A38 JUNCTIONS SCHEME—LITTLE EATON JUNCTION.
APPLICATION FOR DEVELOPMENT CONSENT ORDER.

UPDATED WRITTEN REPRESENTATIONS BY BREADSALL PARISH COUNCIL
TO THE EXAMINING AUTHORITY

This is an update to the representations submitted on 4 November, taking into account the responses received from Highways England to the Examining Authority's first questions and the discussions at the Issue Specific Hearing on December 11th

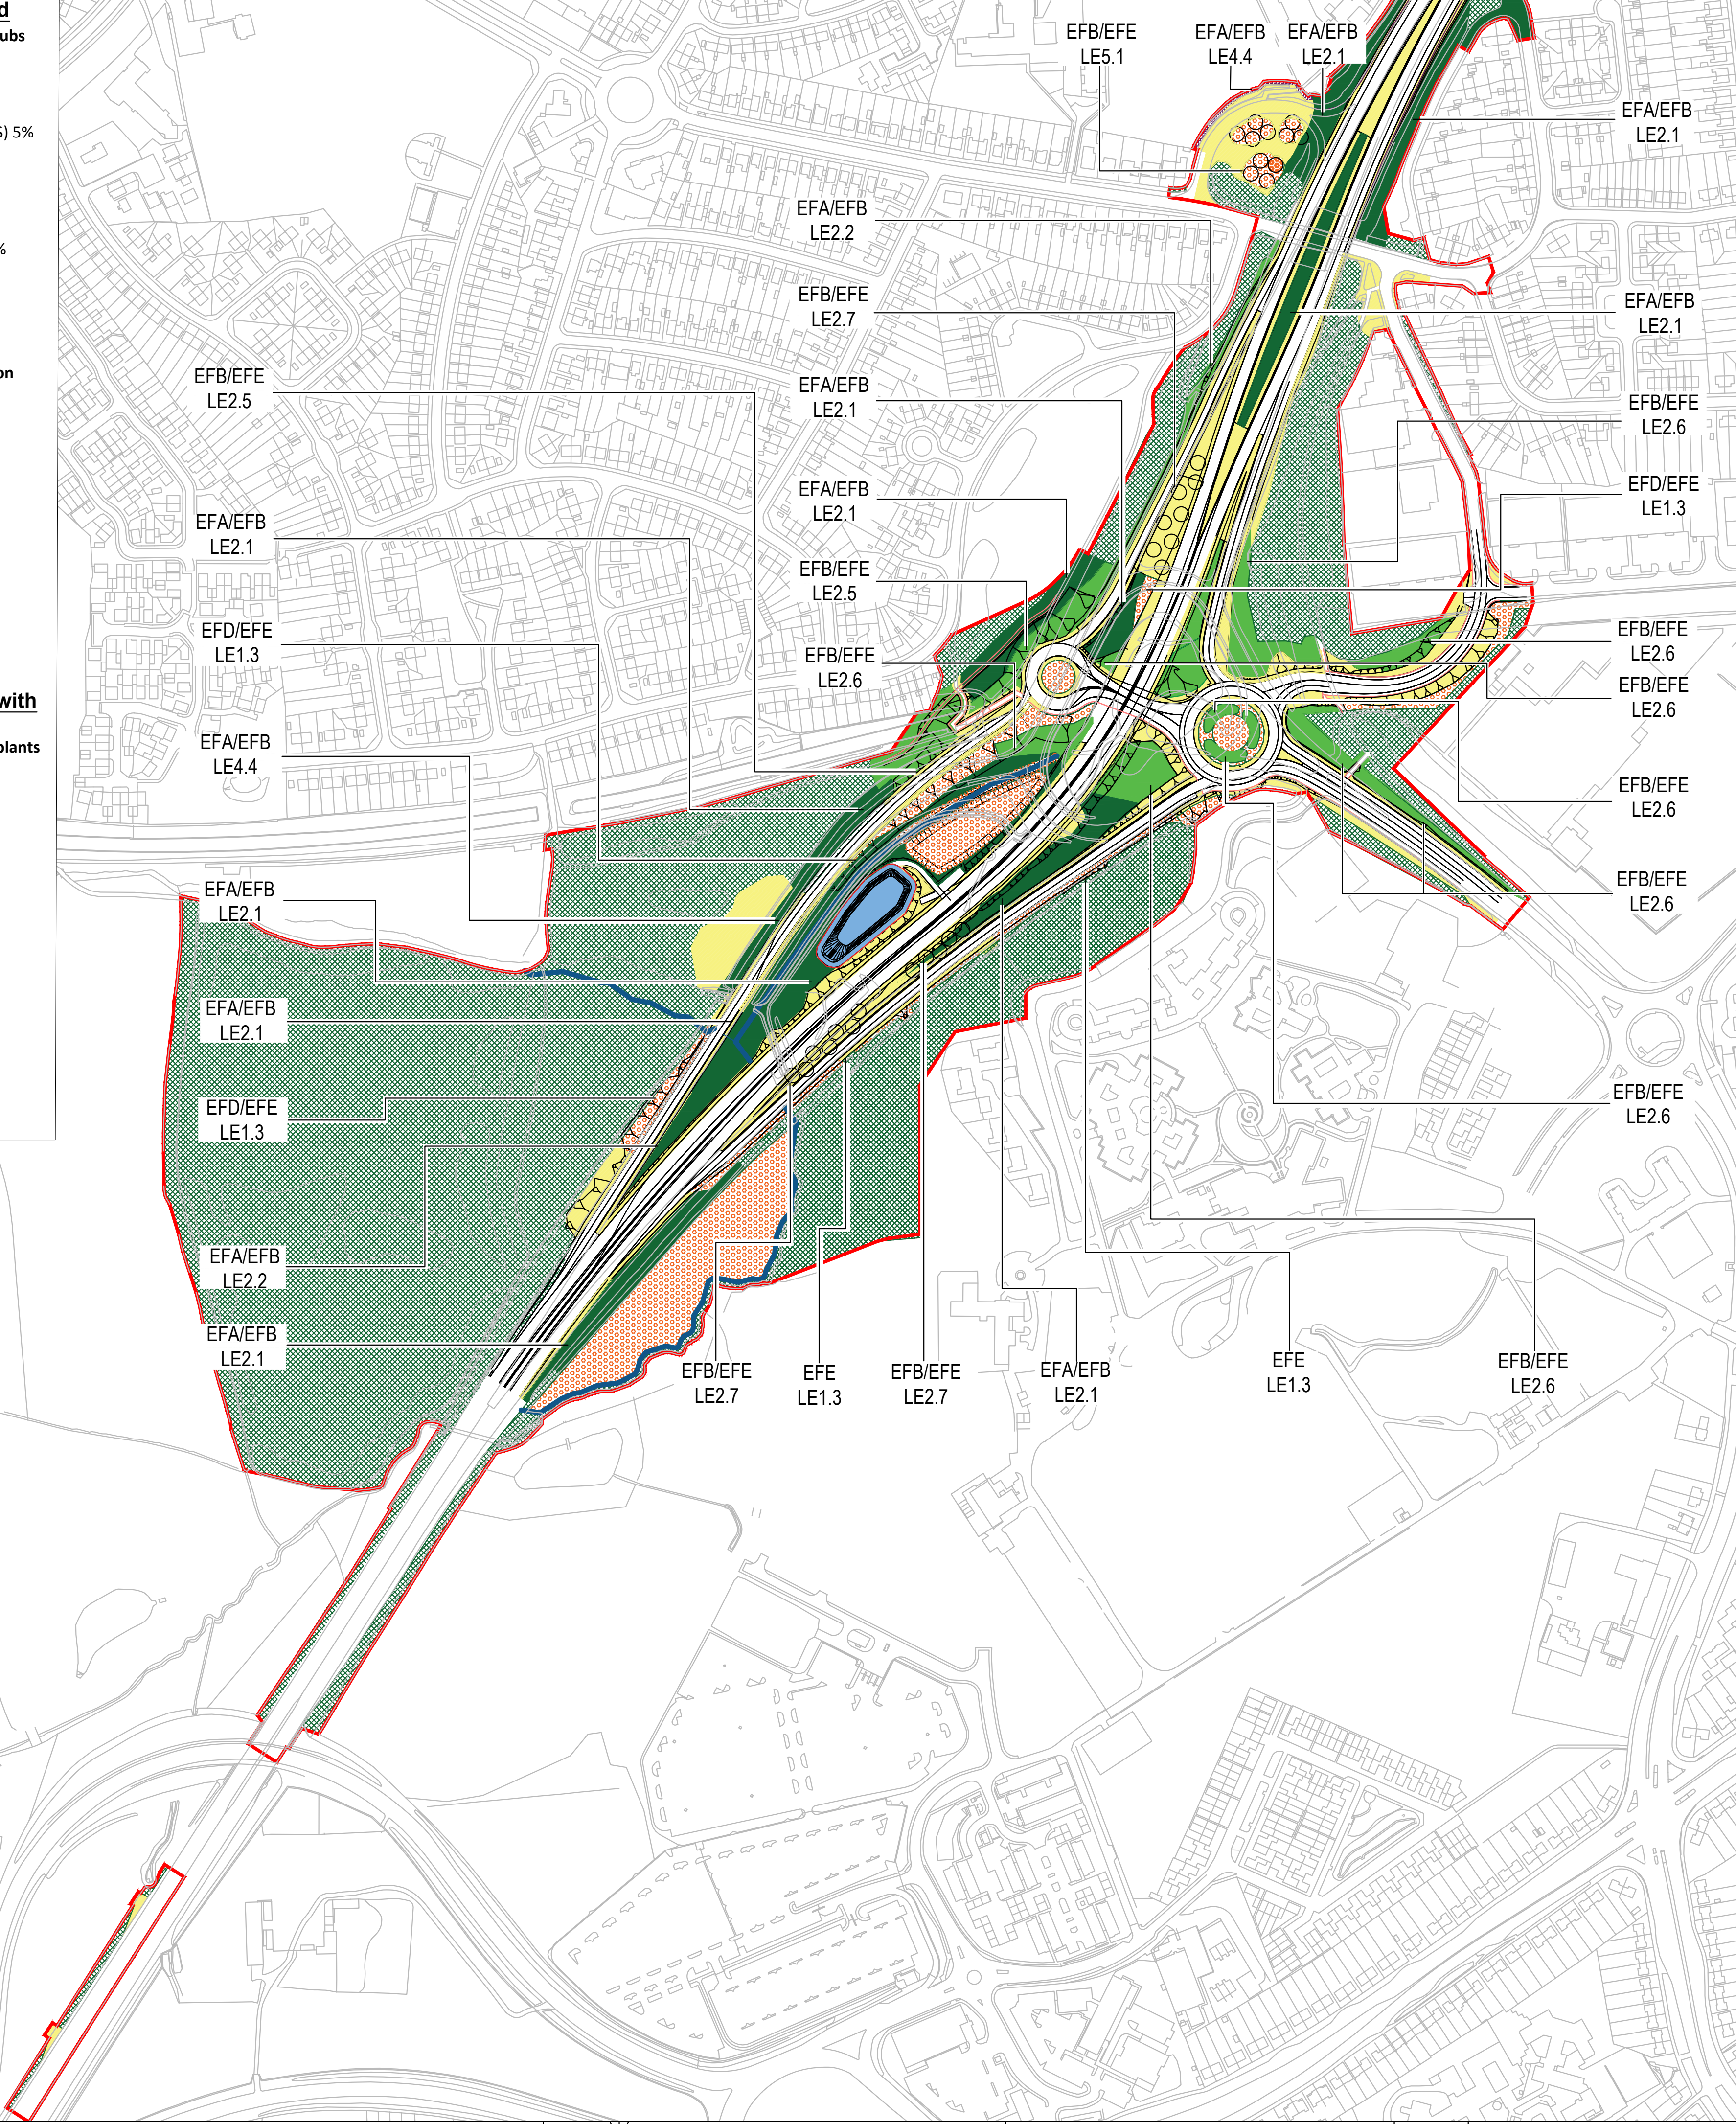
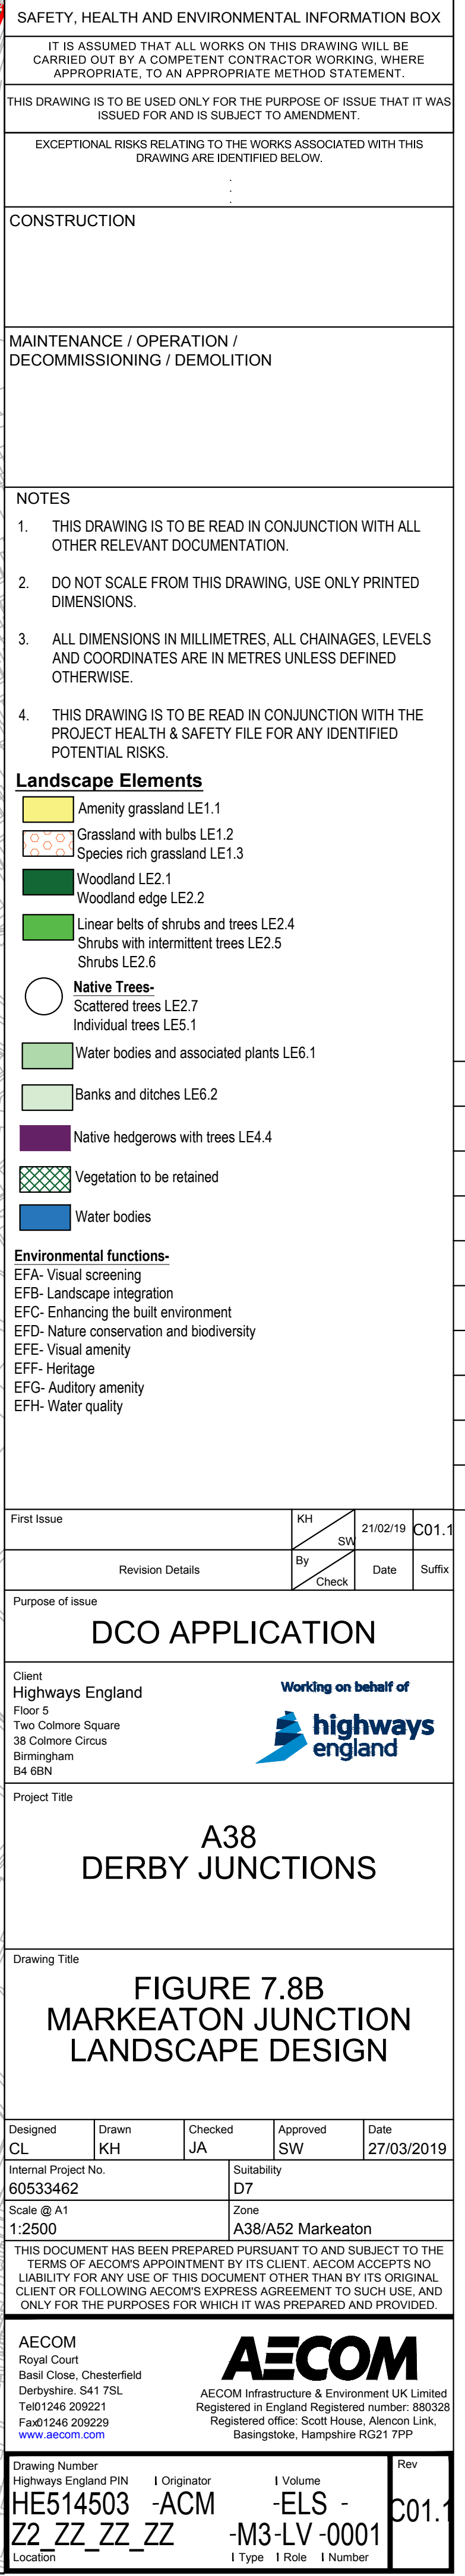
The Parish Council continues to be concerned that the tree belt alongside the southern end of the slip road and the roundabout is far too narrow in the present design to provide effective screening. The discussion at the hearing on December 11th showed that the tree belt at this location is far narrower than those elsewhere around the new junction despite the importance of this particular section in providing a screen between Breadsall and the new road. The Parish Council believes that this provides ample justification for increasing the permanent land take if that is necessary. It is understood that Highways England will in the first instance examine options for moving the ponds eastward to create more space for the tree belt and will liaise with the Parish Council.

Highways England state that the current composition of the tree belts is based on ecological considerations and includes just 10% evergreen species. In this particular location, however, the tree belt has an equally important function in helping to screen Breadsall from the physical effects of the new road. The Parish Council concludes that a much higher proportion of evergreens is needed to provide year- round screening.
